From: Joney Ramirez [REDACTED]
Sent: 16 September 2019 13:09
To: Karl Roberts <Karl.Roberts@arun.gov.uk>
Subject: RE: Application A/100/19/PL - Arundel Acre, Angmering

From: Karl Roberts <Karl.Roberts@arun.gov.uk>
Sent: 06 September 2019 09:51
To: Joney Ramirez [REDACTED]
Subject: Application A/100/19/PL - Arundel Acre, Angmering

Visibility Primary Direction (North)

1711056-SK01

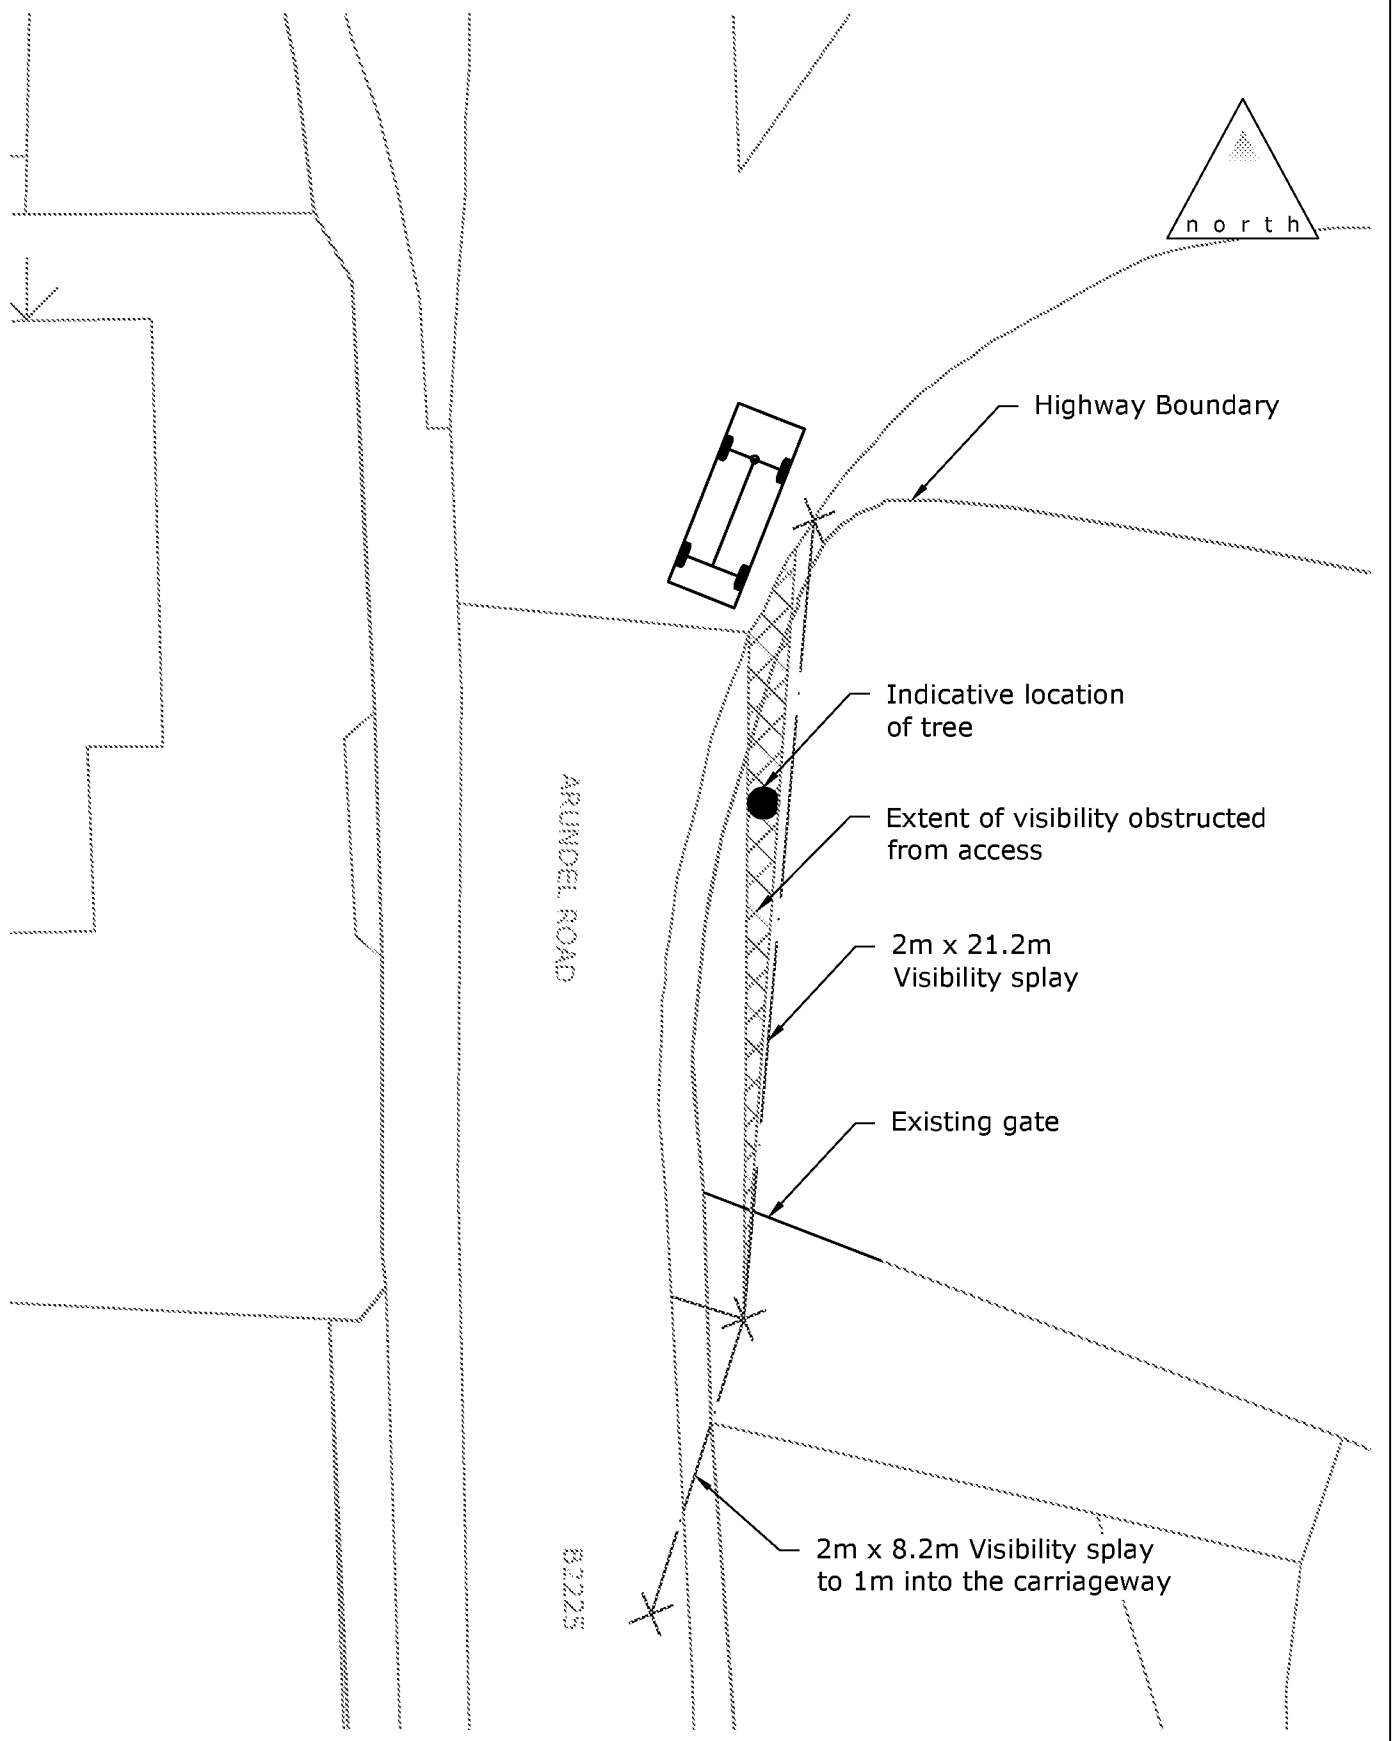
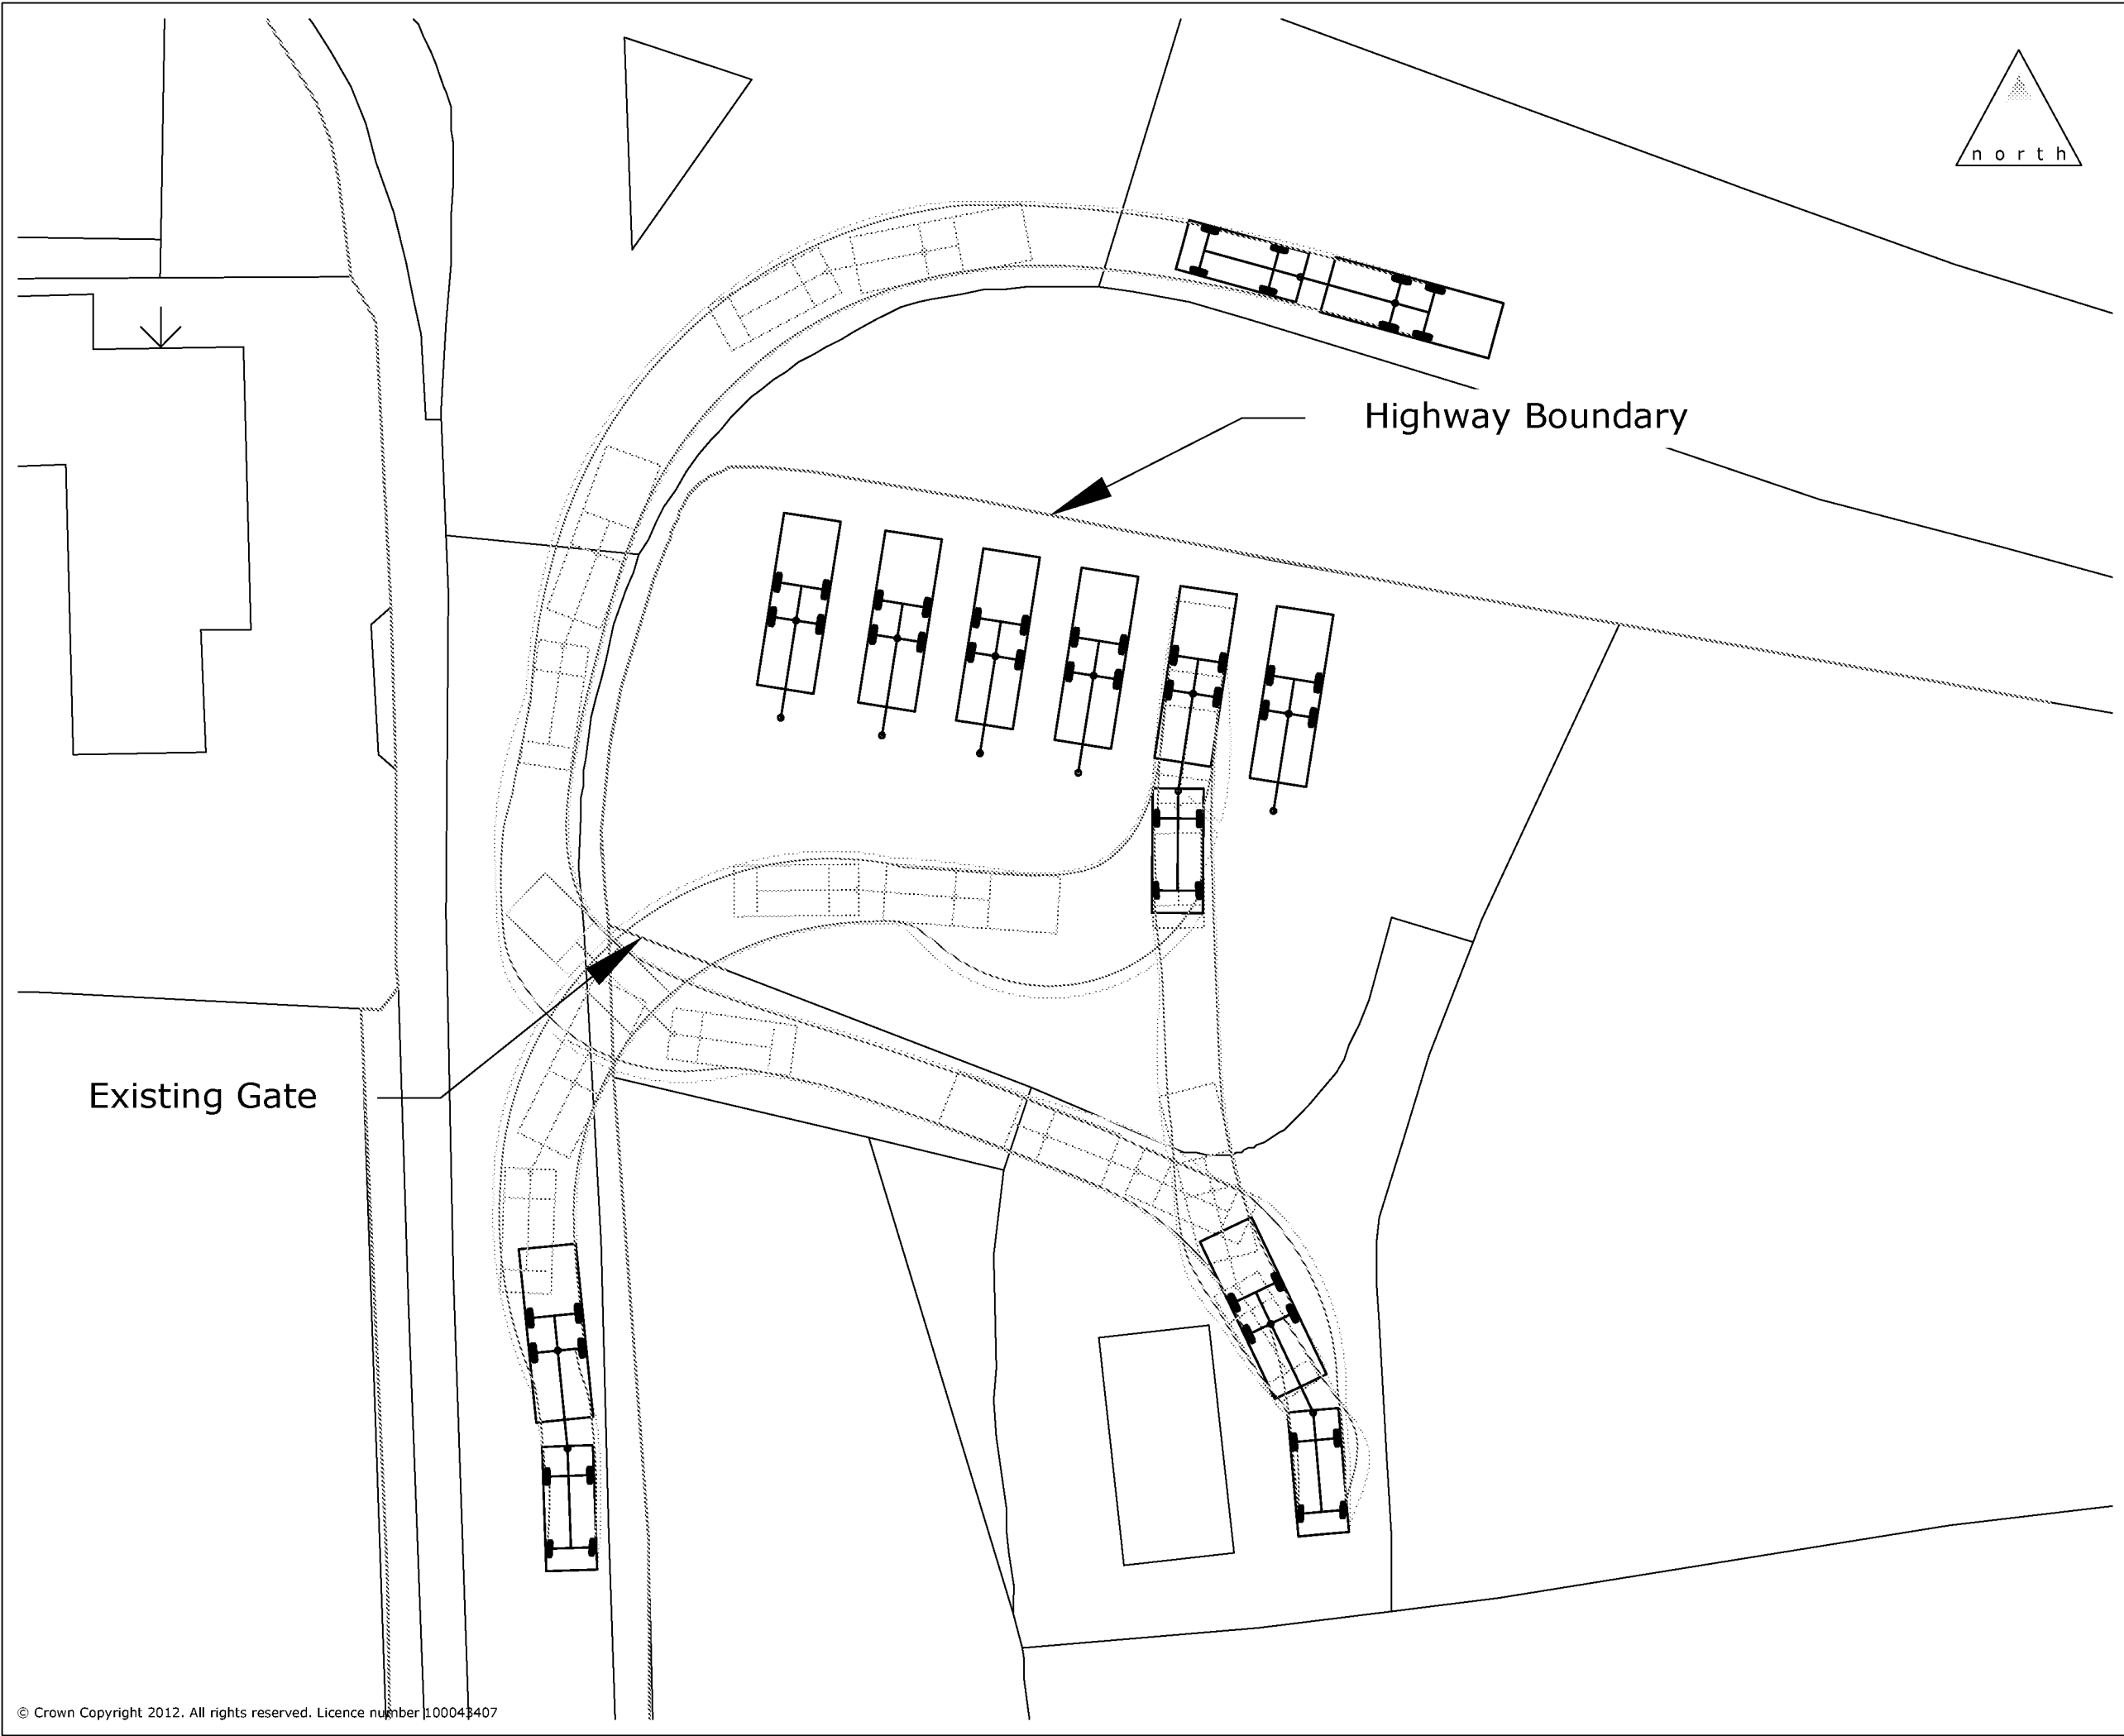
Visibility Trailing Direction (South)

As previously assessed under A/111/17/PL & A/3/18/PL visibility in the trailing direction was extremely limited due to 3rd party land. The maximum available visibility was demonstrated as 2.0 x 8.2 metres, measured 1.0 metre into the carriageway. The LHA did not accept that a 2.0 metre 'X' distance should be used. Nevertheless this would only equate to the stopping sight distance of an approach speed of 7 mph as per Manual for Streets calculation coefficients.

No evidence, previously or as part of this application has been provided to demonstrate such visibility is suitable or that any significant improvements could be made.

The additional information will comprise an ATC survey from the north, to ascertain vehicle speeds and hence informing the required visibility splay from the south. We will also provide new access arrangements to address the visibility issues and tracking diagrams to evidence vehicles will be able to enter the site without safety issues.
